Rezoning Transportation Analysis
Petition Number: Insert Zoning Petition #2020-194
General Location Identifier: Tax ID 11906424

Revision Log:	Date	Description
	01-21-2021	First Review (KP)
	02-12-2021	Second Review (KP)
	03-25-2021	Third Review (KP)
	04-27-2021	Fourth Review (EL)

**REZONING PLAN
RZ.01**

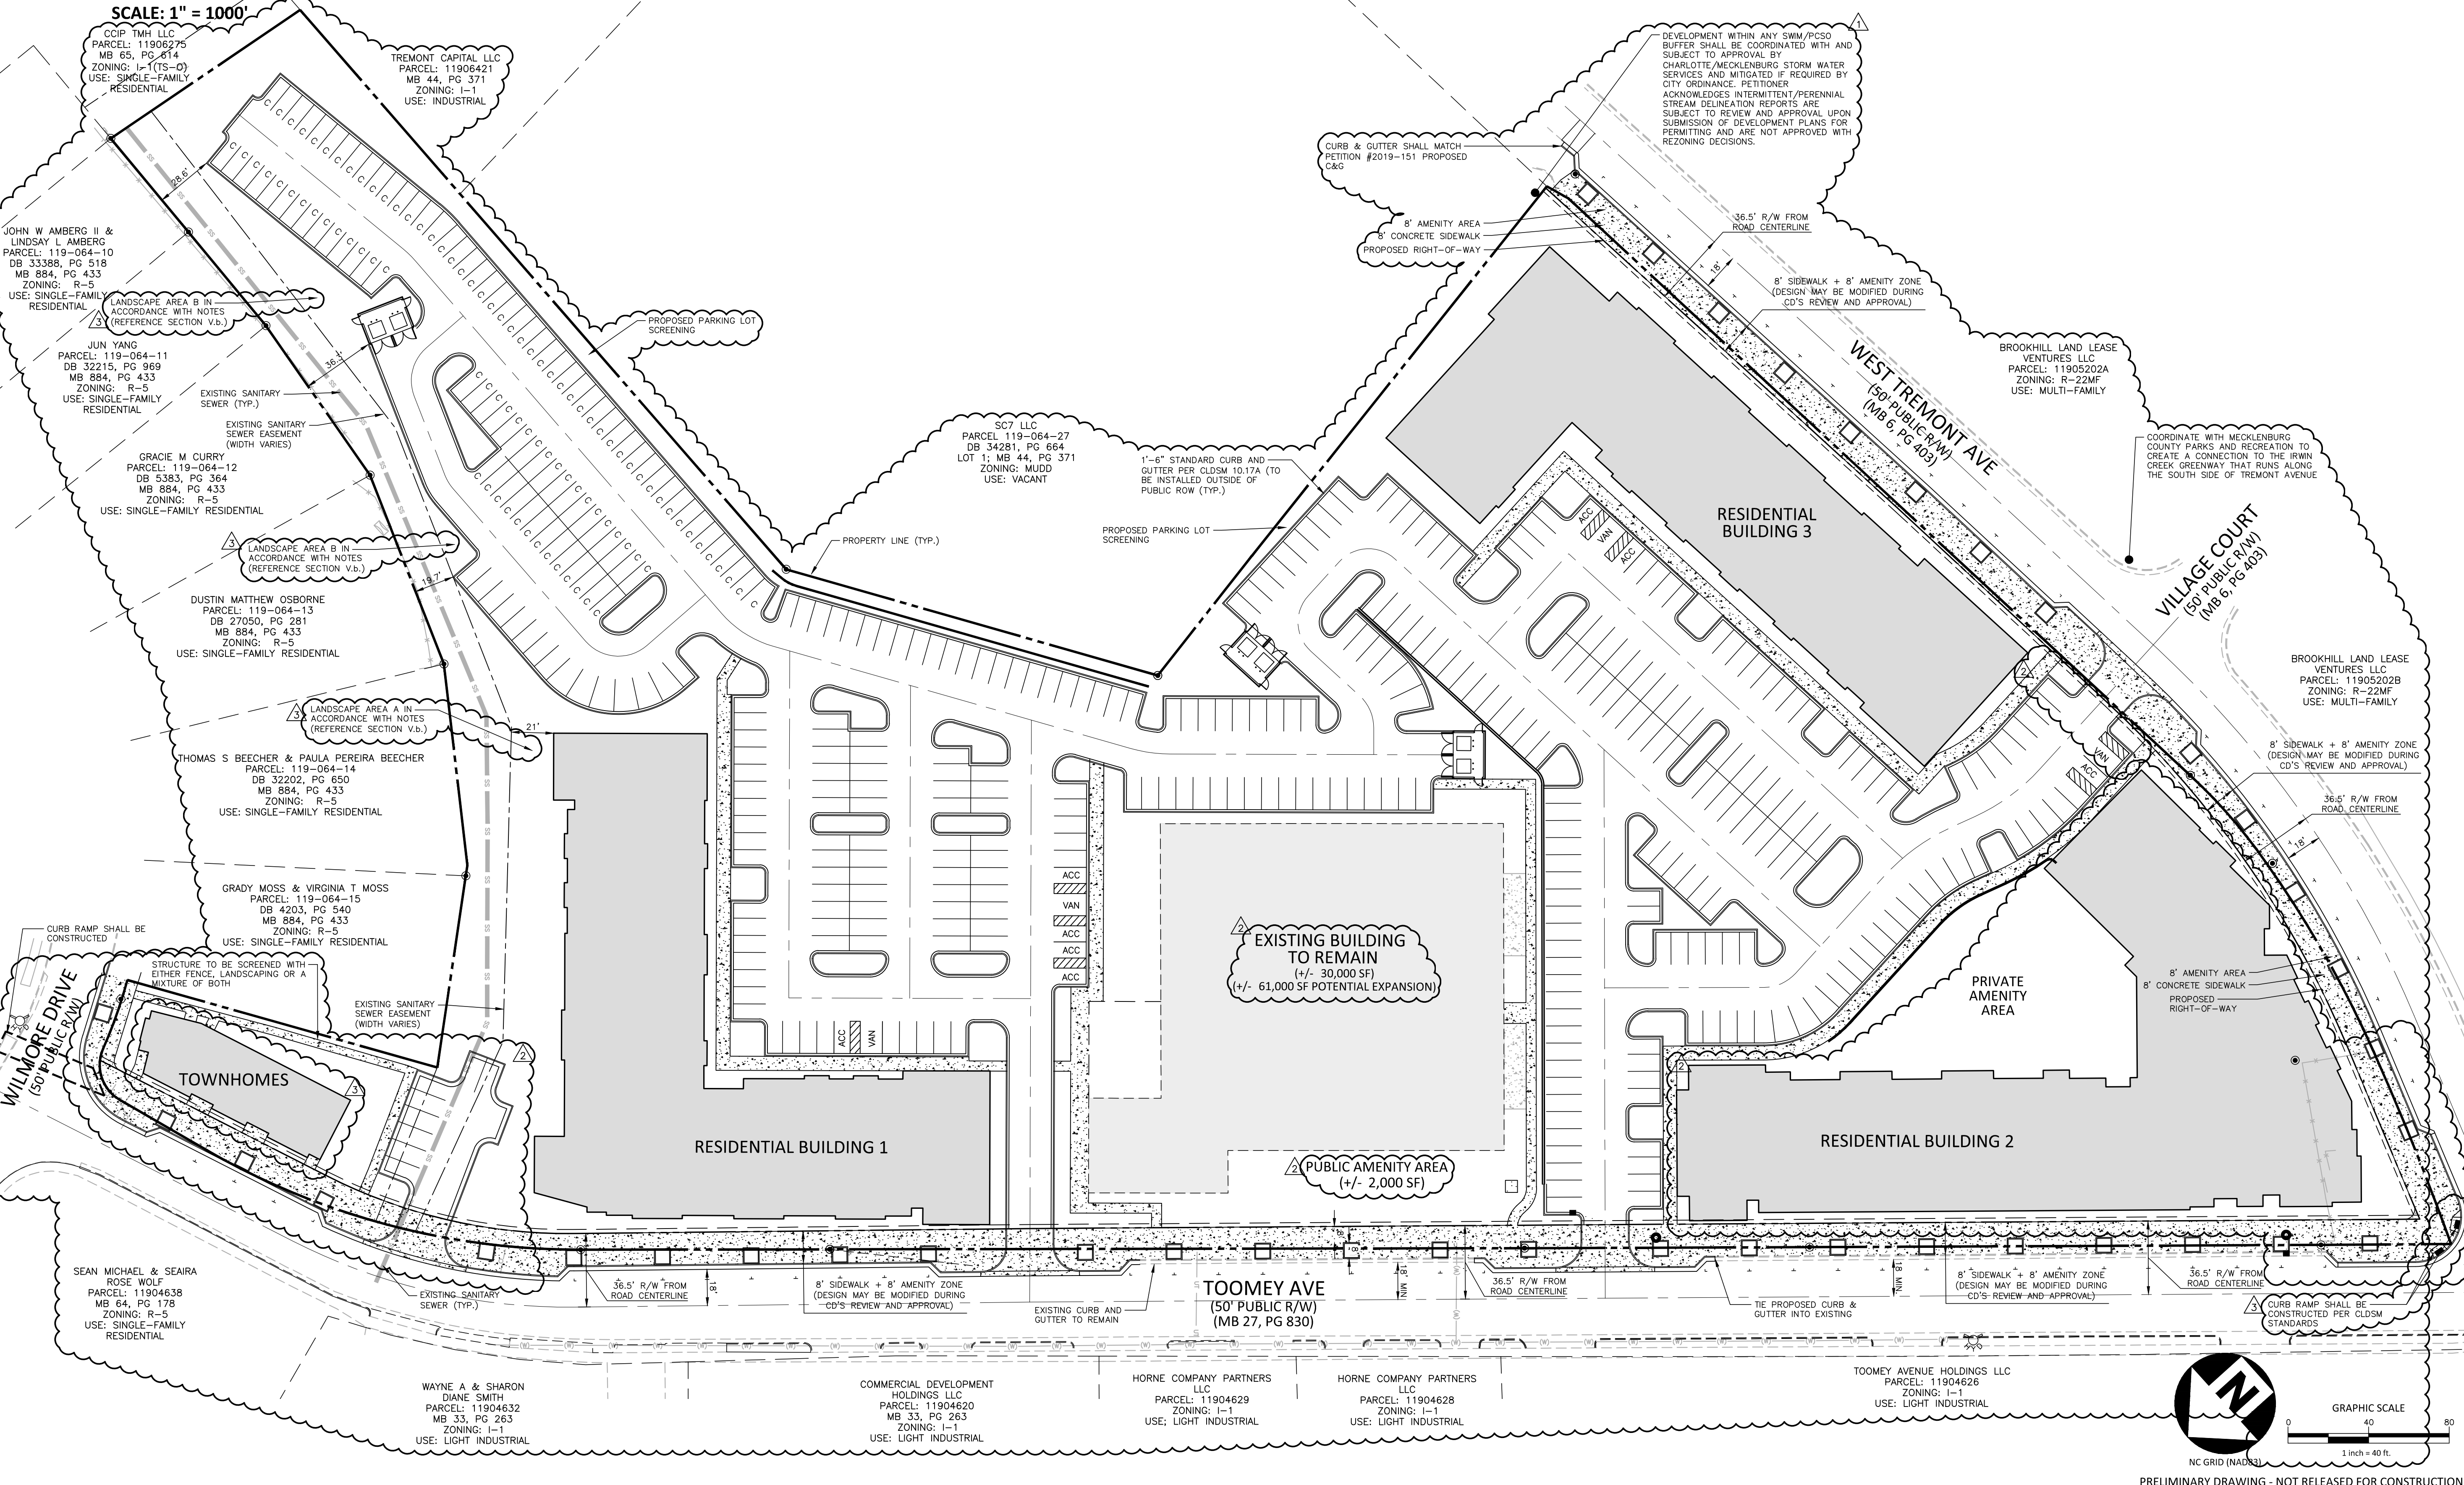
10. Revise site plan and conditional note(s) to commit to construct a CLDSM 10.31A curb ramp at the southeast corner of the Toomey Avenue and Wilmore Drive intersection.

11. A site plan note(s) specifying dedication and fee simple conveyance of all rights-of-way to the City before the site's first building certificate of occupancy is issued is needed. CDOT requests rights-of-way set at 2' behind back of sidewalk where feasible

12. A site plan note specifying that all transportation improvements will be approved and constructed before the site's first building certificate of occupancy is issued is needed. The petitioner may phase
